# Planning and Urban Development Department

**Subject:** B-2b Design Review – 89 Anderson Street  
**Written by:** Caitlin Cameron, Urban Designer  
**Date of Review:** Tuesday, August 2, 2016

The project at 88 Preble Street was reviewed according to the *City of Portland Design Manual* standards by Caitlin Cameron, Urban Designer against *the B-2b Commercial Business Zones Standards* (Section (d) of the Design Manual).

**CONCEPT DRAWINGS  
 NOT FOR CONSTRUCTION**  
**EAST ELEVATION**

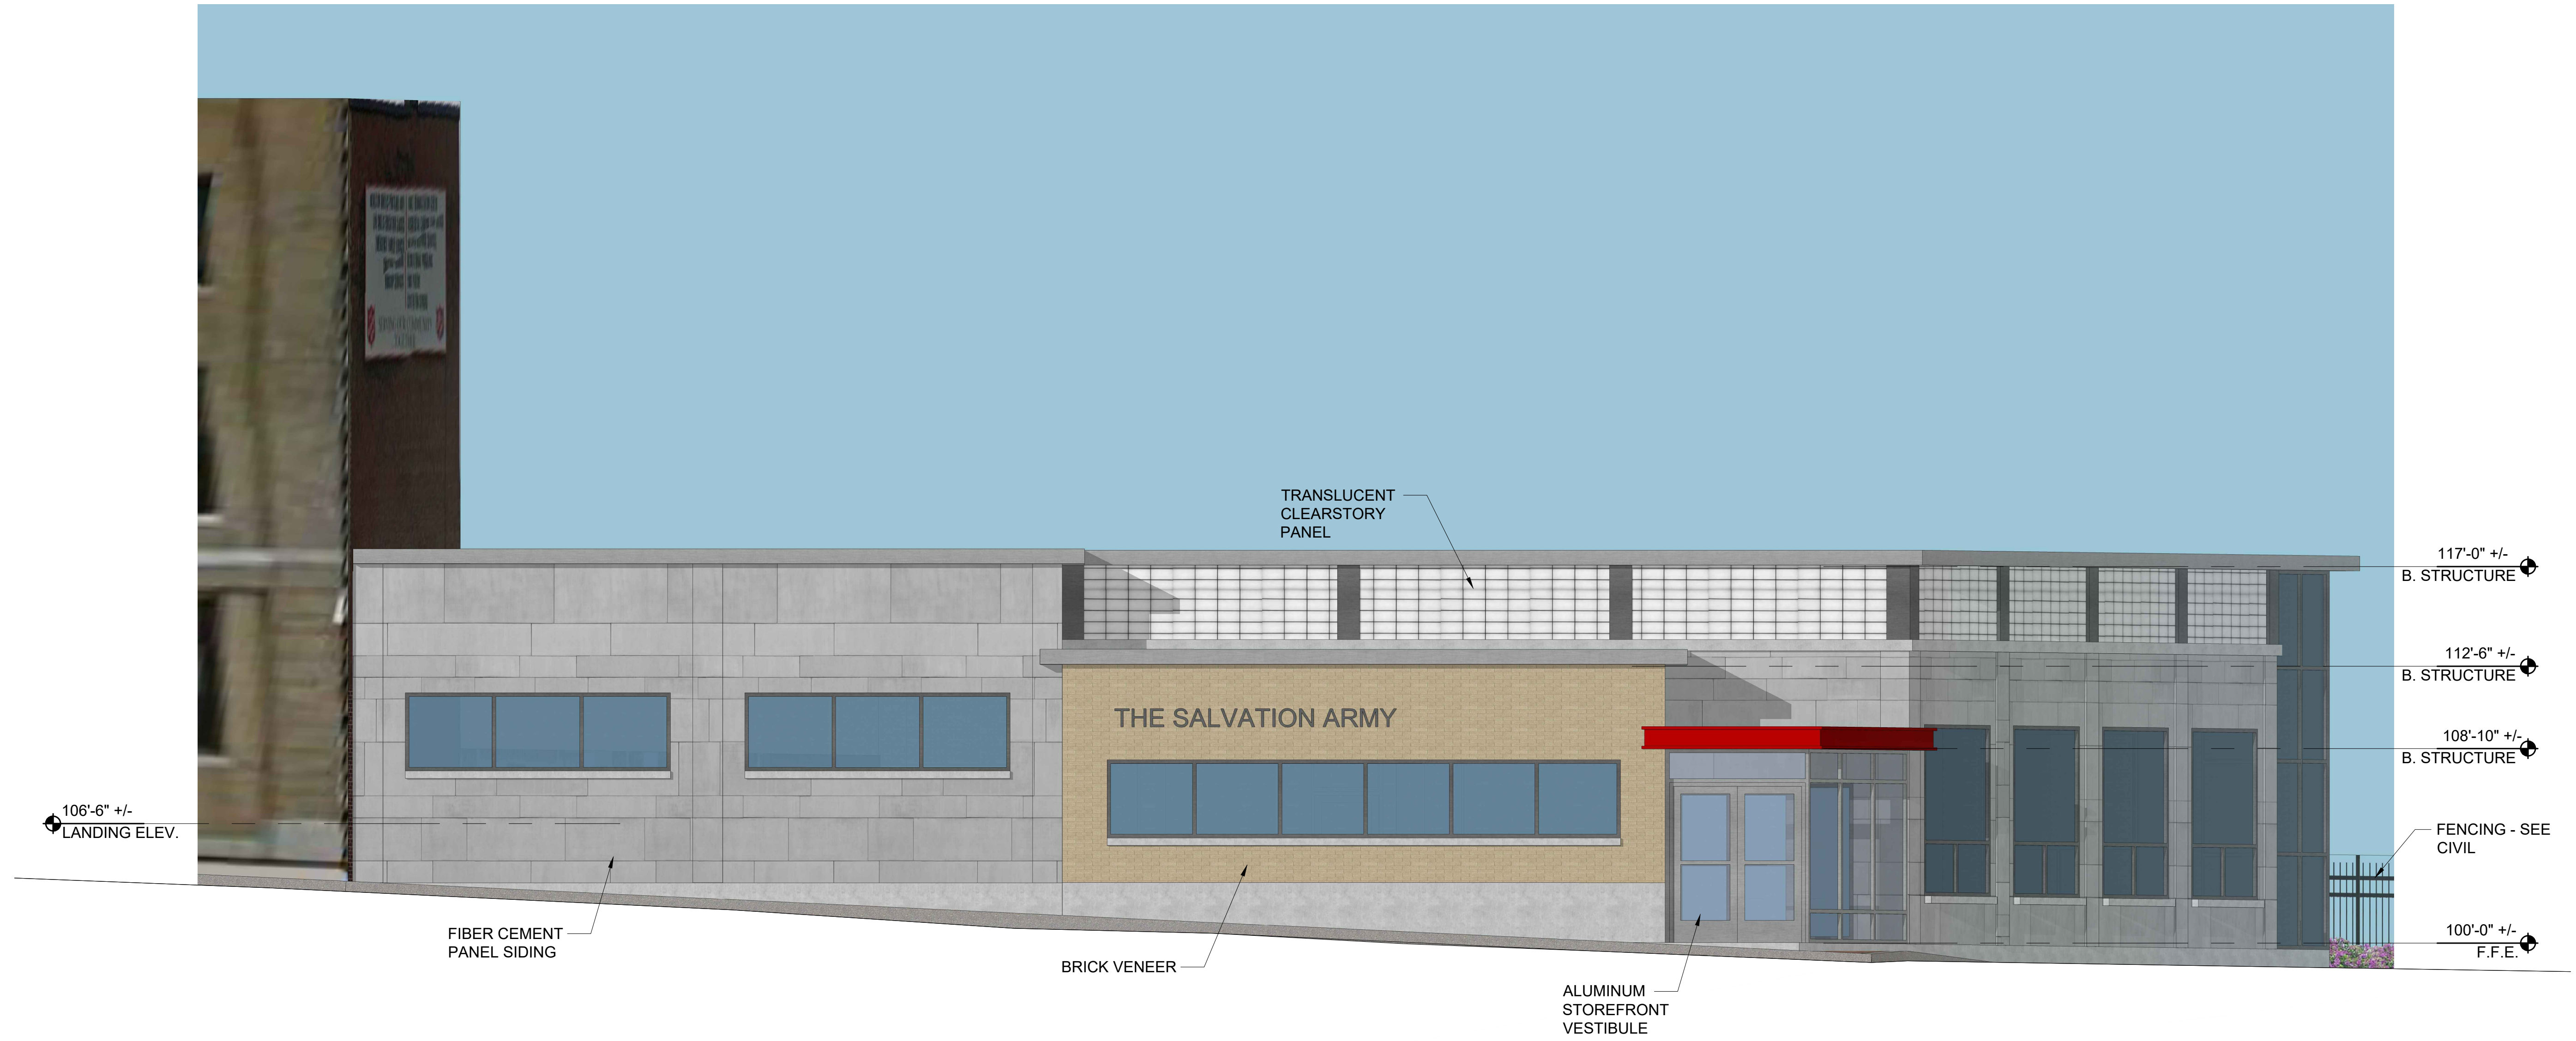
*Standard (1) d. Windows* – Met – Ground floor street frontage has an adequate amount of fenestration and at a level that provides some views into the building while maintaining some privacy for the users. **Fenestration should meet the minimum transparency standard.**

*Standard (1) e. Façade Character* – Met – Street-facing facades are oriented to and/or adjacent to public sidewalk. Fenestration is set higher than for a retail space in deference to ramp and desire for some privacy of users.

*Standard (1) g. Building Materials* – Met – Material choices seem appropriate and in character with the surrounding context. **It was suggested to applicant that the more durable concrete base be brought up higher on Preble Street.**

**CONCEPT DRAWINGS  
NOT FOR CONSTRUCTION**  
**NORTH ELEVATION**

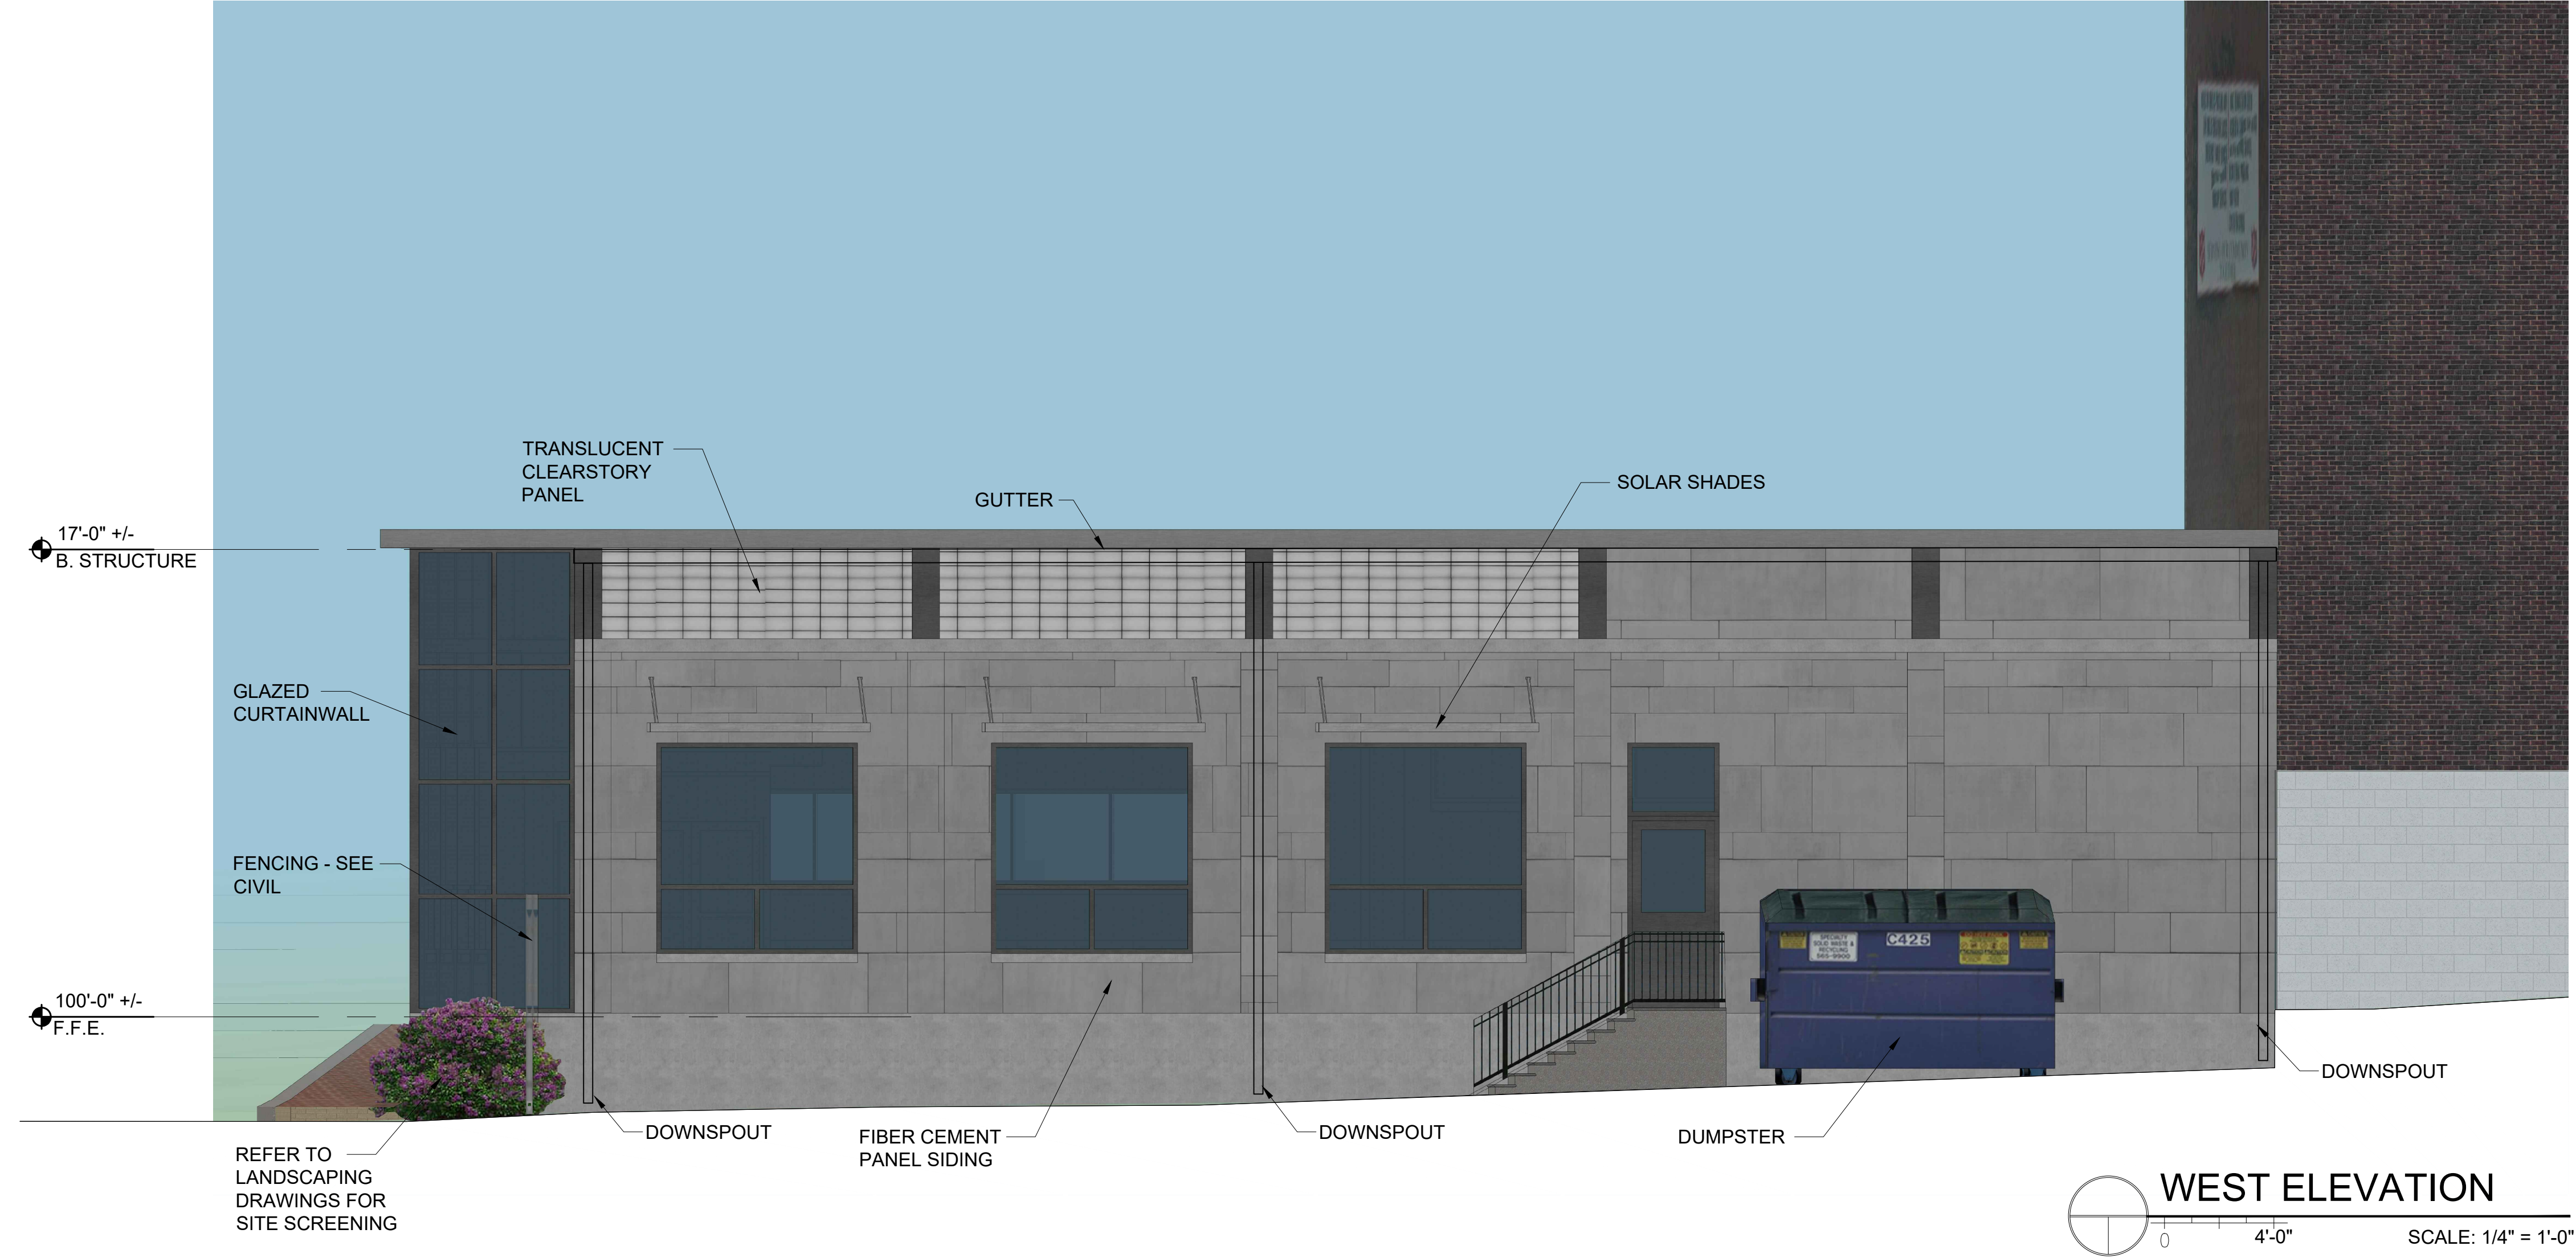
*Standard (1) f. Building Design* – Overall, the building design is compatible with the surrounding context in its scale, roof pitch, and fenestration. Although multi-story building design would be preferable here, one story is allowed by zoning and the applicant has designed a tall one-story that meets the datum line of the adjoining building.
